Project # 1001979

Project Name: **ARROWHEAD RANCH DEVEL.**

DEVELOPMENT REVIEW BOARD
October 23, 2002
Project # 1001979

02DRB-01497 Minor-Prelim&Final Plat Approval

2002162646
 5768626
 Page: 4 of 6
 12/06/2002 02:11P
 BK-2002C Pg-398
 Mary Herrera
 Bern. Co. PLAT R 32.00

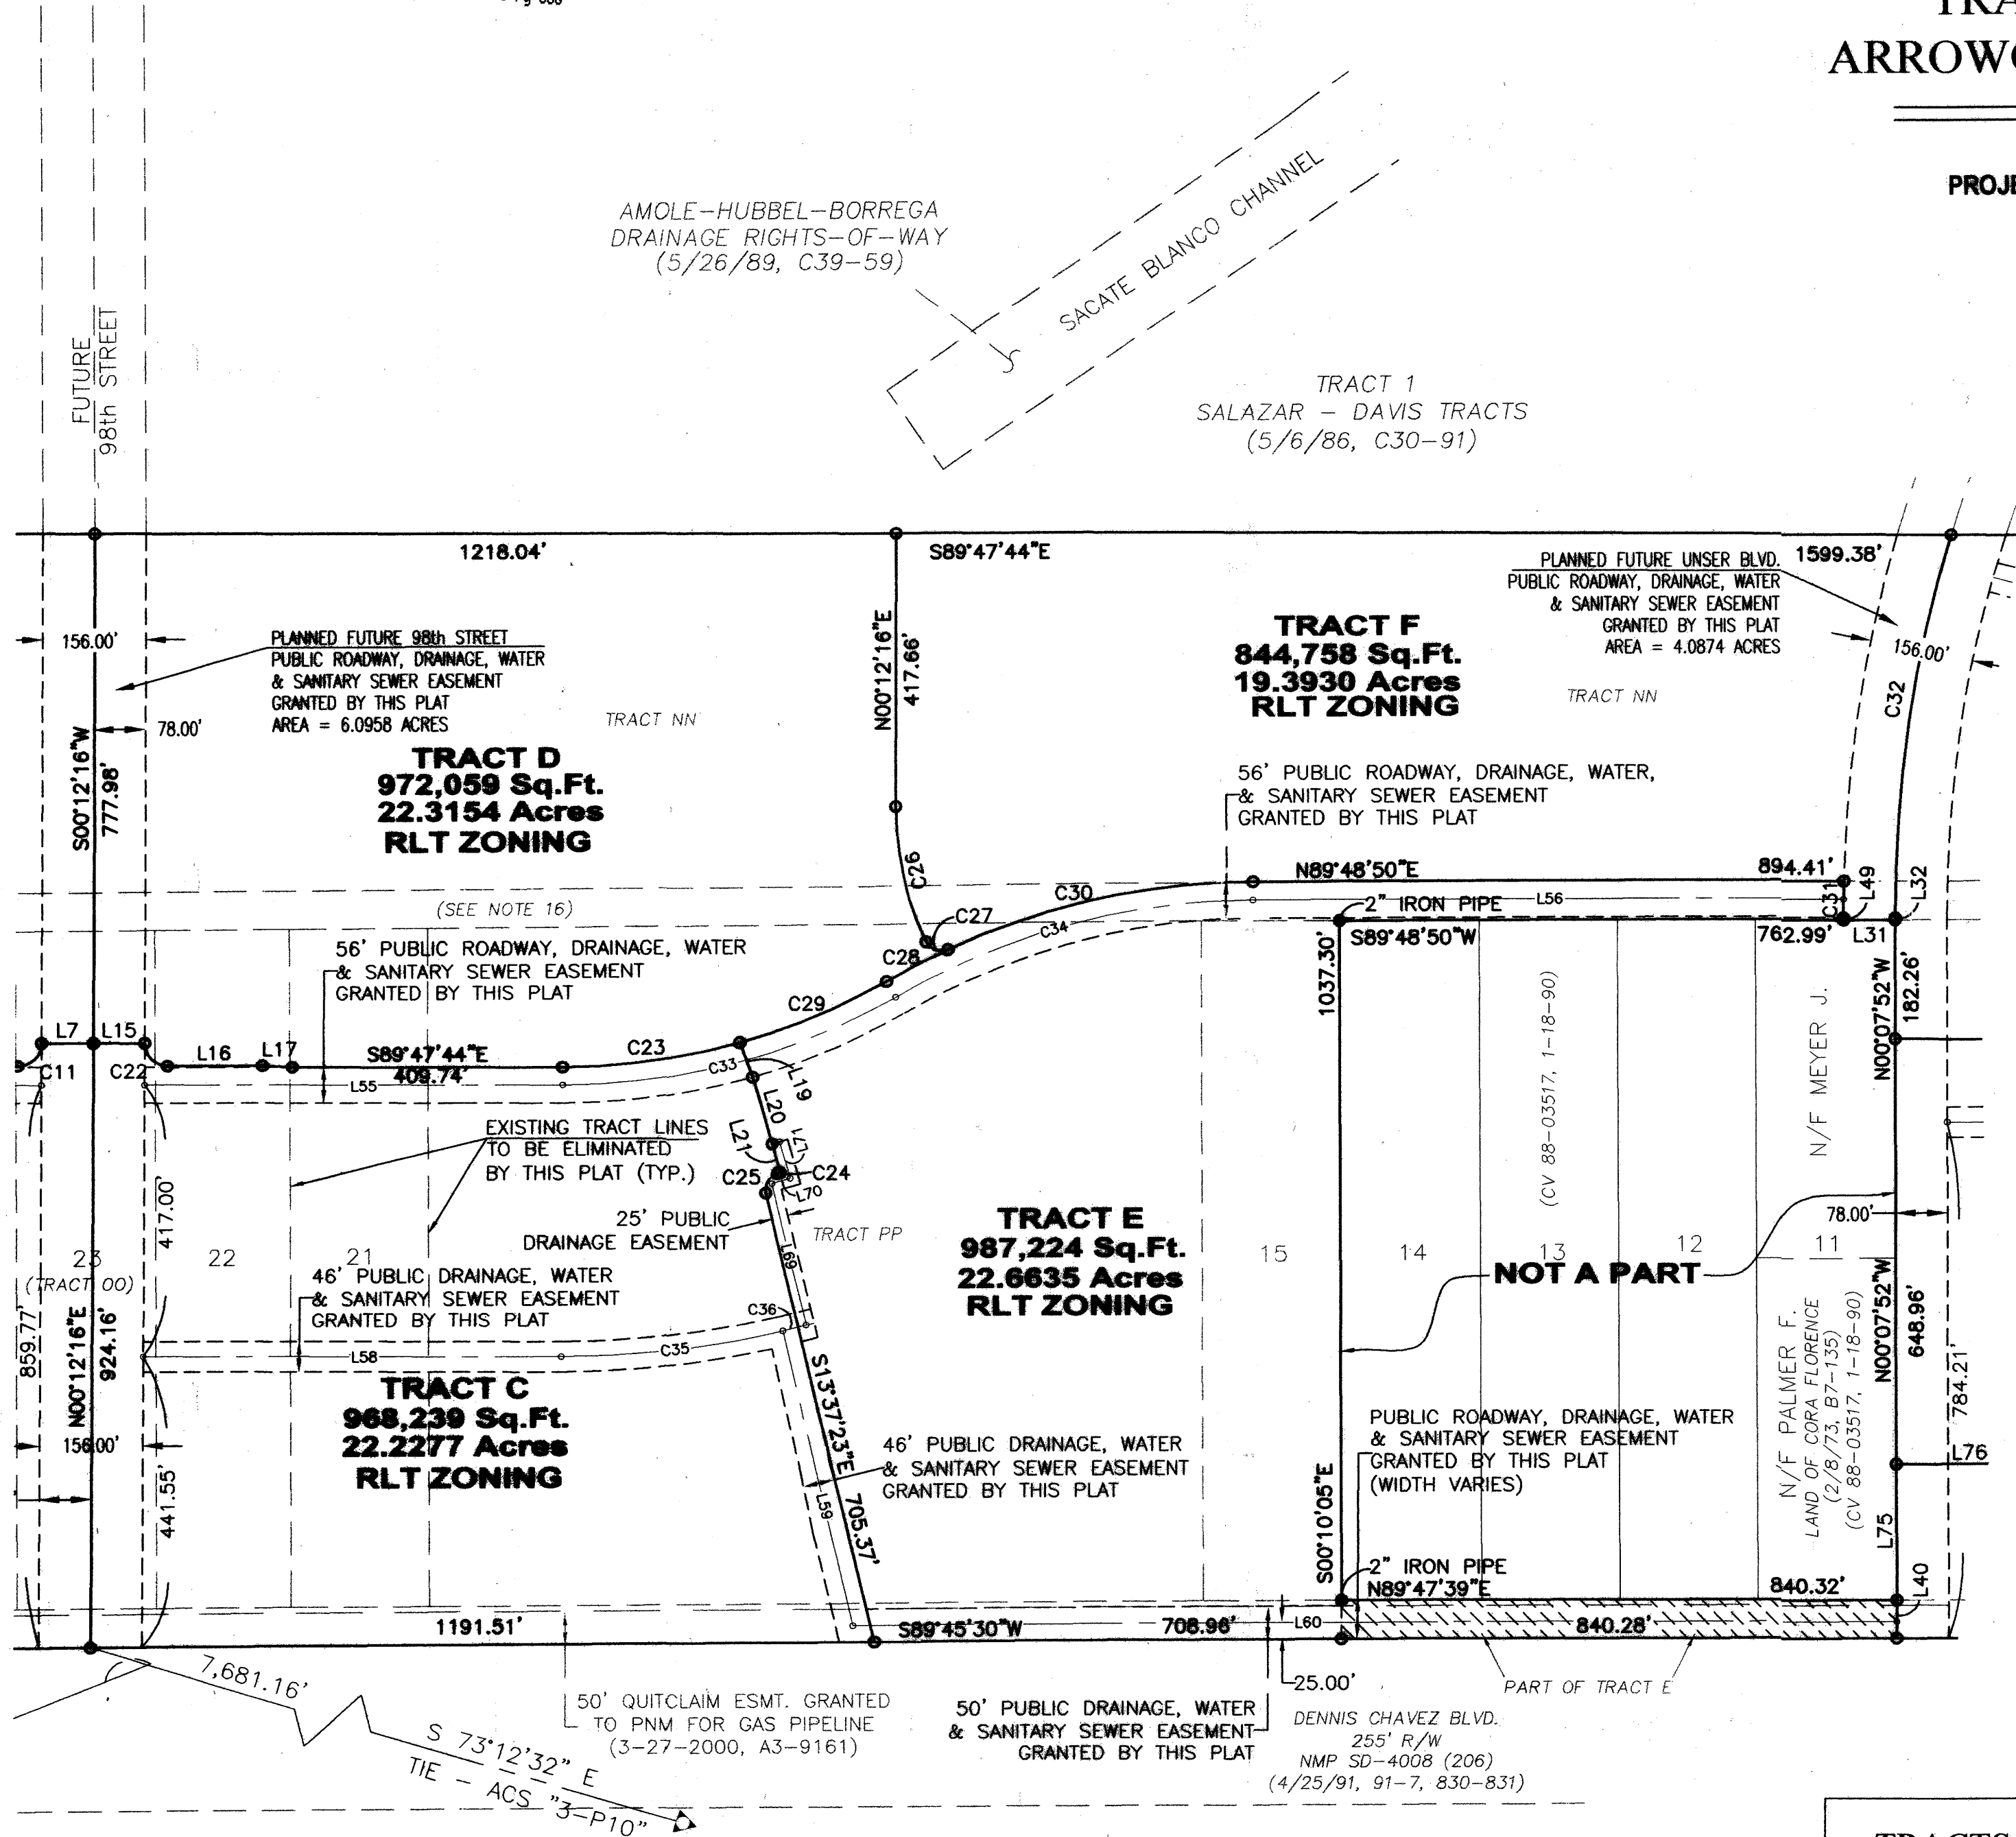
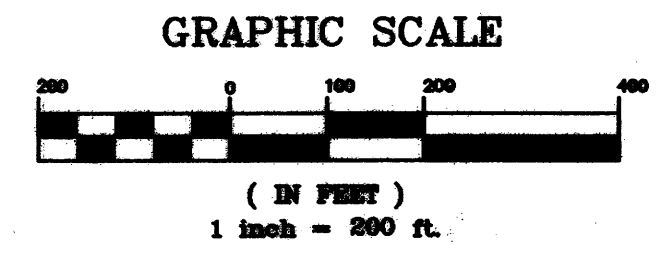
3. Add the Application # for the bulk land variance and the preliminary/final plat adjacent to the Subdivision Case No. on the plat.
4. Refer to Sheet 4 of 6. It appears that existing tract lines on the "Not A Part" tract are being eliminated and that a public access, public drainage, public water and sanitary sewer easement are being granted by the plat. Please clarify/revise as appropriate.
